August 28, 2024

Re: West Magnolia (FKA East Sunnyside) PRD/BSP – Final Plat *Technical Review 1*
PA22-033

City of Marysville Community Development – Planning Division

# WEST MAGNOLIA

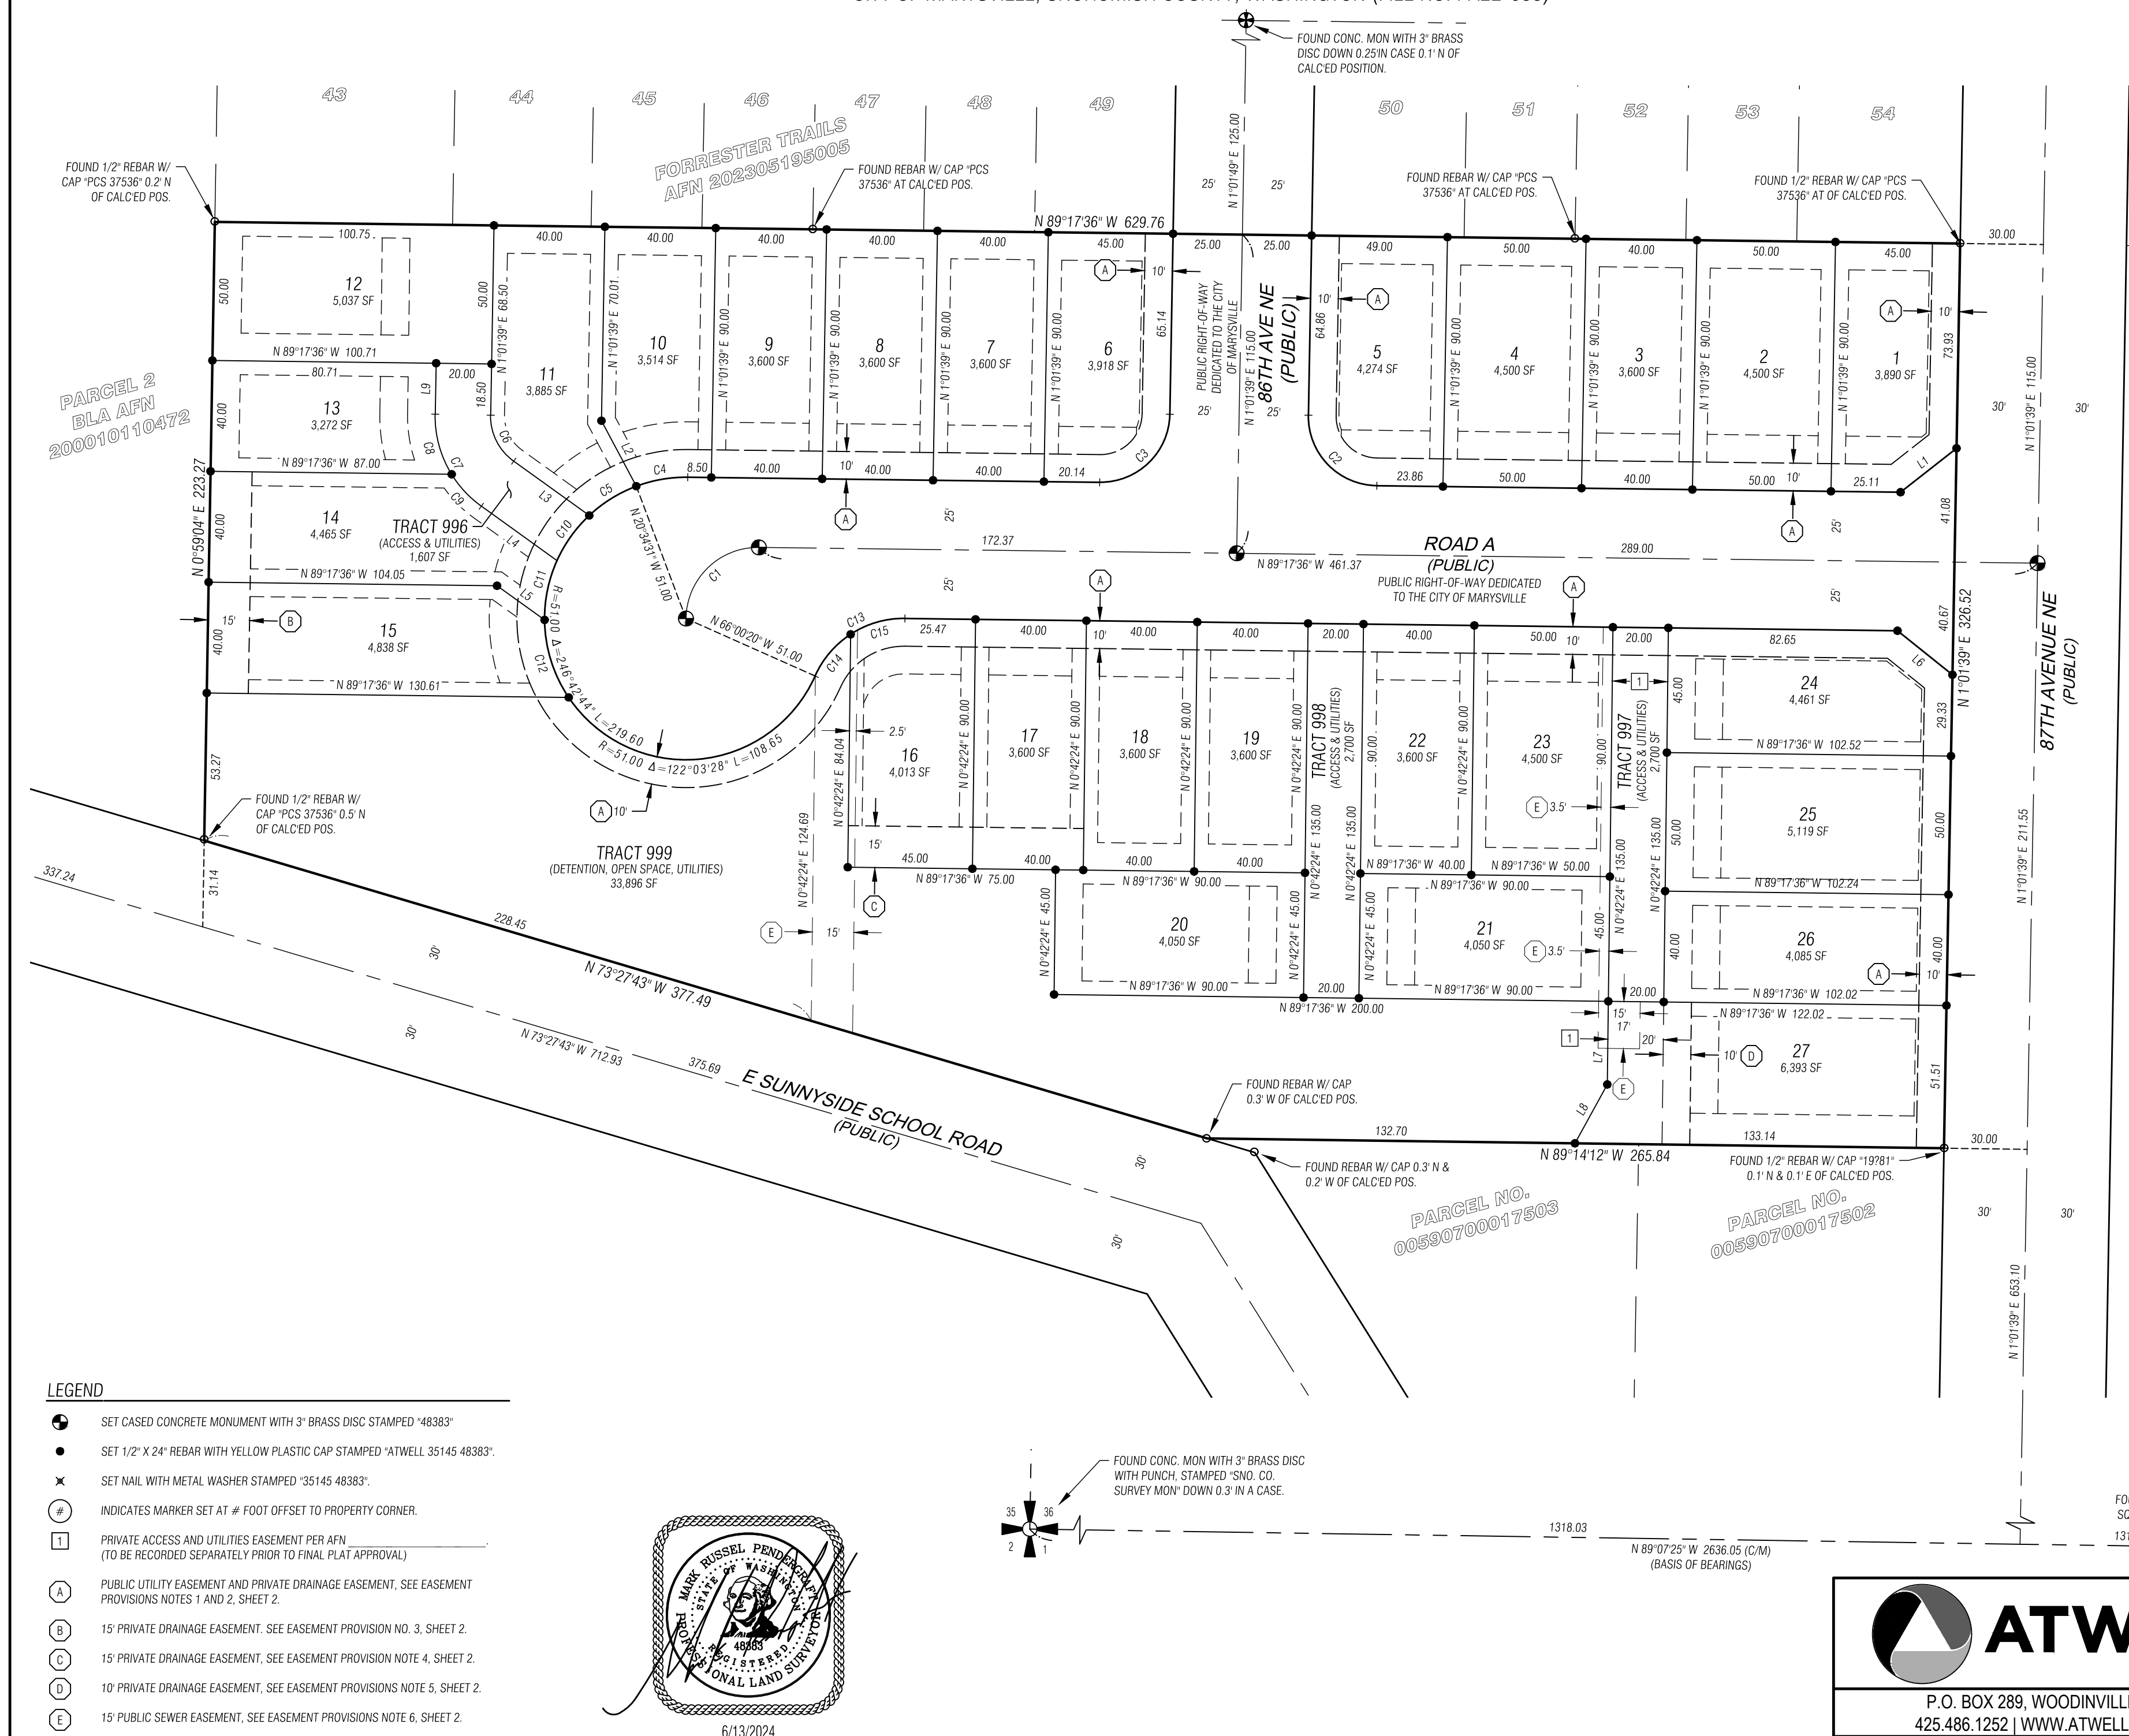
- g. On Sheet 4:
 - i. Lot 13 is less than the minimum lot size of 3,500 square feet.
 - ii. Under Tracts 996 and 997, amend to read "private access and utilities".

- iii. Depict Snohomish PUD easement and reference AFN#202401100143
 - iv. Label all assigned road names
2. Amend the access easement agreement benefitting parcel #00590700017503 to include utilities as well as access.

- 30. Several lots in the Lot Closures do not match the plat map
 - 31. Sheet 1, lower left corner has overlapping text.
 - 32. Sheet 4, distances along Road A right of way are missing.
 - 33. See attached "Site Plan Markups 2".
-
